**KIRKLEES METROPOLITAN COUNCIL
INVESTMENT & REGENERATION SERVICE**

DELEGATED DECISION TO DETERMINE PLANNING APPLICATIONS

Reference No:	2024/62/92303/E
Site Address:	74, Station Lane, Birkenshaw, BD11 2JE
Description:	Erection of single and two storey rear extension and detached garden room
Recommending Officer:	Edward Cheseldine

DECISION – Conditional Full Permission

Drawing title
Garden Room - Plans & Elevations as
Proposed

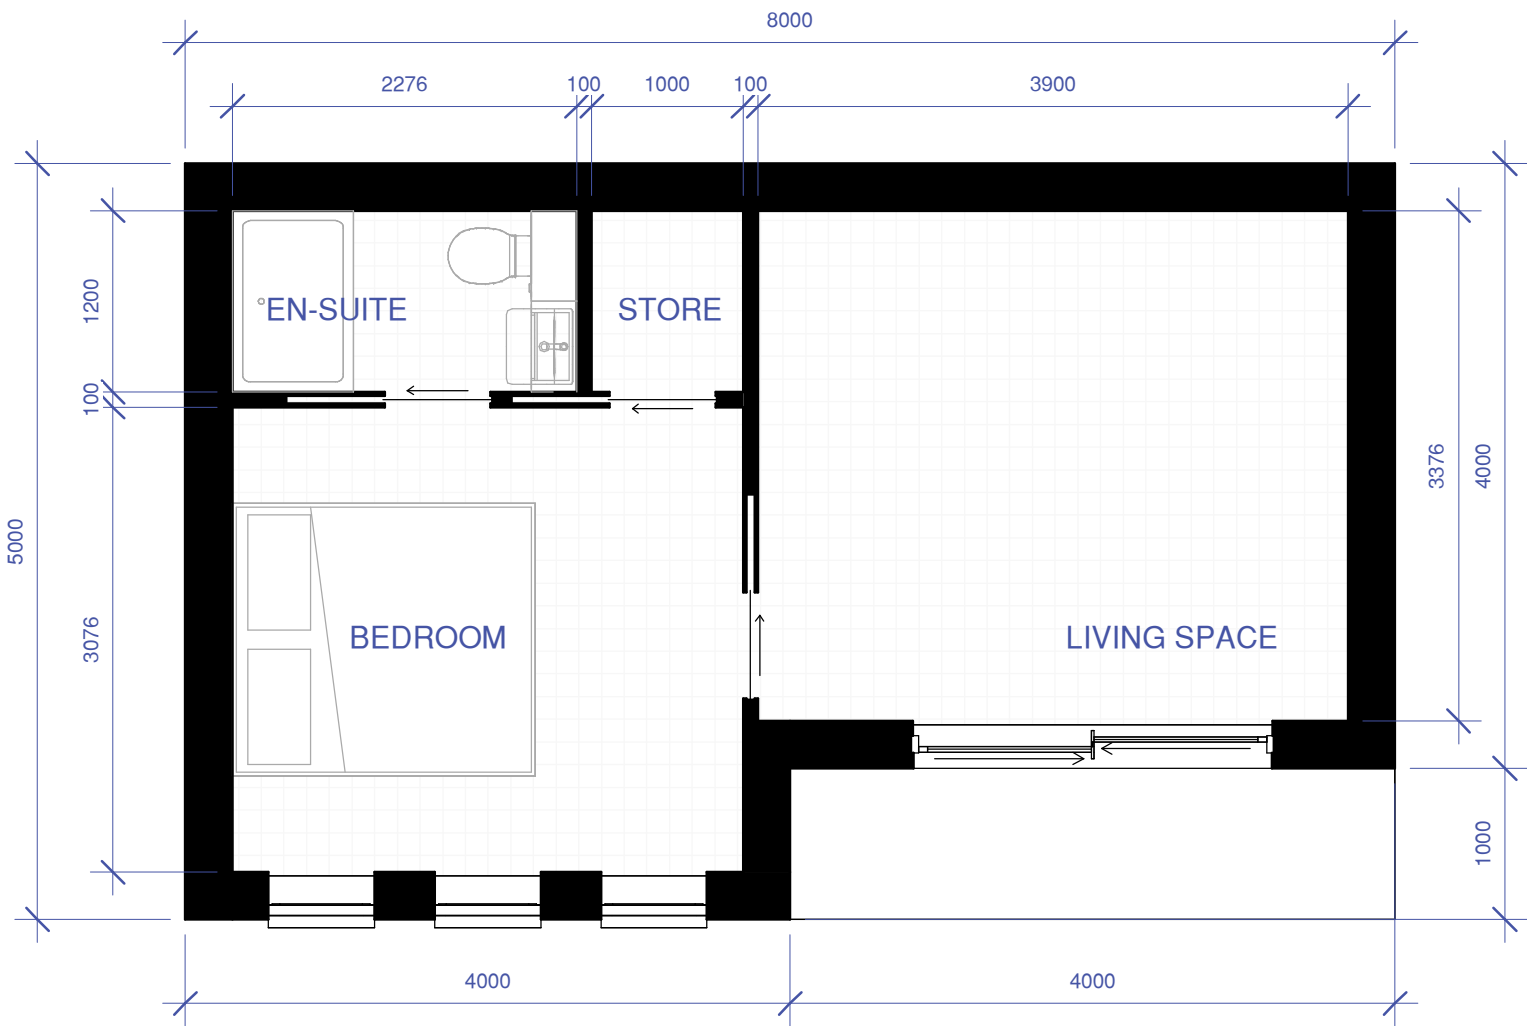
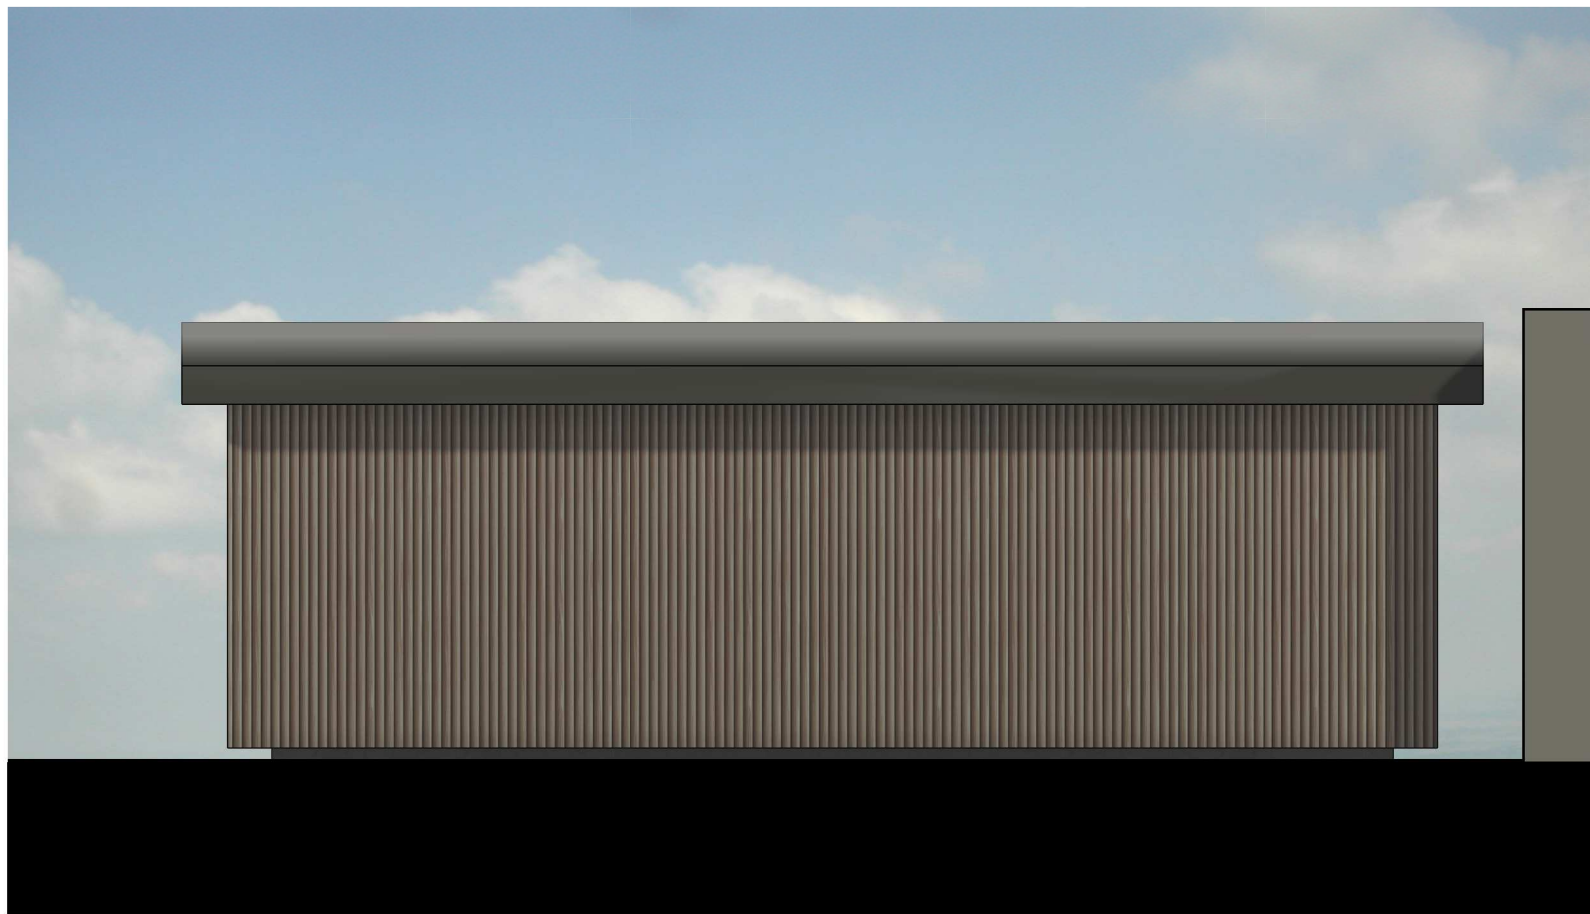
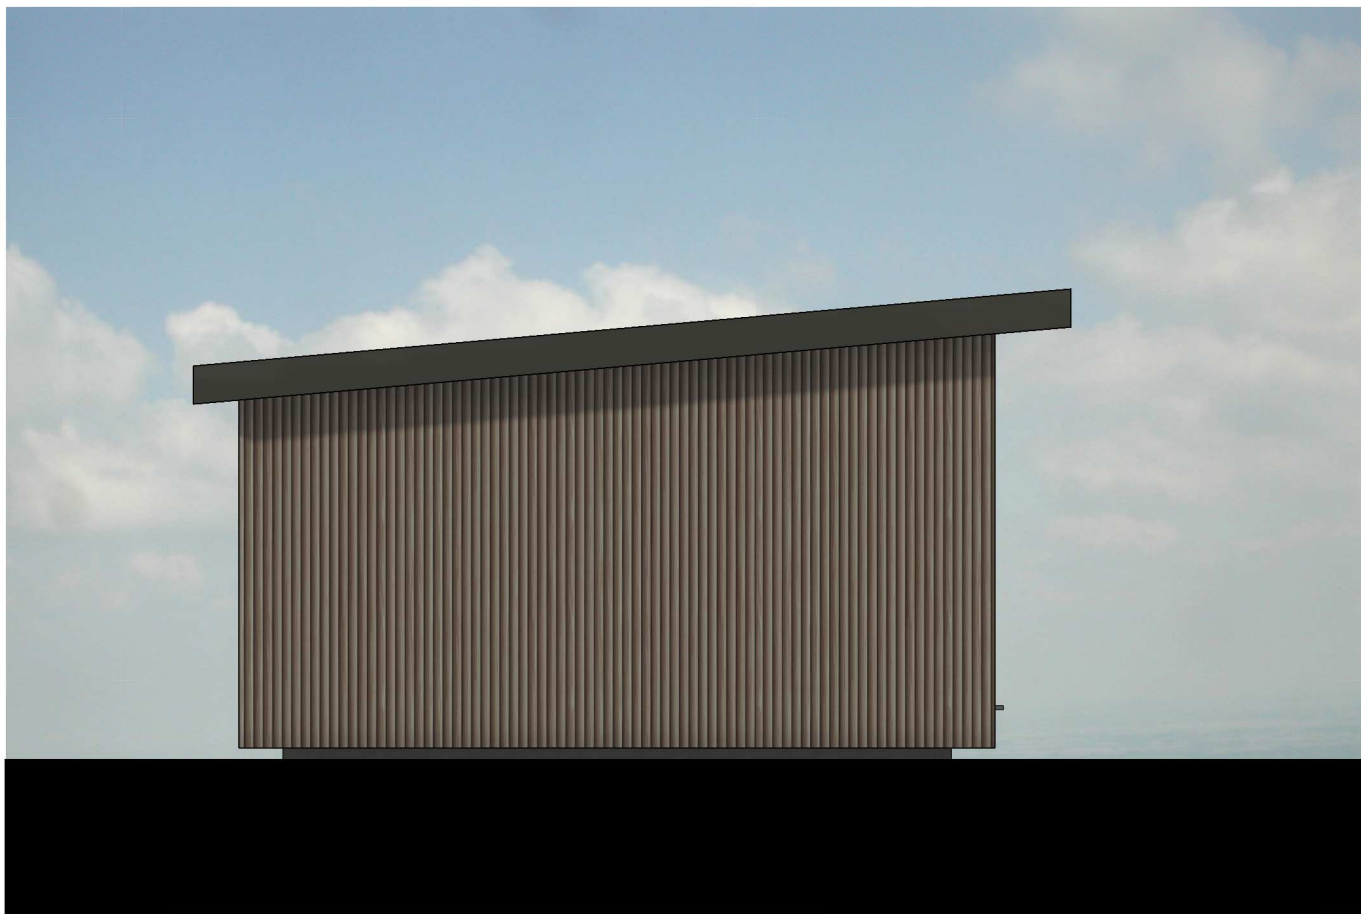
<u>Yes - COMPLY</u>	<u>No - JUSTIFY</u>
Be subservient in footprint and scale to the original building and its garden taking into account other extensions and existing outbuildings		Whilst the garage is a large structure, the garden space can accommodate such a building. It is a single-storey building. The structure will not compete with the existing dwelling in terms of scale or design.
Be set back behind the building line of the original building so that they do not impact on the street scene		The outbuilding will be set to the rear garden, it will not be visible within the streetscene.
Preserve a reasonable private amenity space appropriate to the potential number of occupants of the house, and follow a general principle that no more	~190m2 of rear outdoor garden space will be retained which is suitable for a dwelling of this size.

Chapter 12 of the NPPF		
Facing materials and detailing	- KDP 9 of the SPD - Policy LP24 Design (d) (iii) of the KLP - Chapter 12 of the NPPF	Materials of the rear extension will match the host dwelling. The outbuilding will be timber clad, which given the distance of separation is acceptable.	✓
Roof style	- KDP 1 and 2 of the SPD - Policy LP24 Design (a), (c) and (d) of the KLP - Chapter 12 of the NPPF	The roof of the rear extension would be hipped, drawing the mass away from the neighbouring dwelling. It extends the original roof form.	✓
Window proportions	- KDP 1 and 2 of the SPD - Policy LP24 Design (a), (c) and (d) of the KLP - Chapter 12 of the NPPF	Window proportions of the rear extension match the proportions of the existing dwelling. The windows of the outbuilding are modern in approach, complementing the buildings contemporary design.	✓

Relevant key design principle (KDP) of the SPD, Policy in the Kirklees Local Plan and the NPPF	Further comments	✓ / X / N/A
Impact on privacy of neighbours (to sides, rear and front)	• KDP 3 & 4 of the SPD • Policy LP24 Design (d) (iv) • Chapter 12 of the NPPF	In terms of the outbuilding, it will have windows with an outlook from habitable windows that face No. 72. There is a separation distance of 18.00m to the first-floor windows.	✓
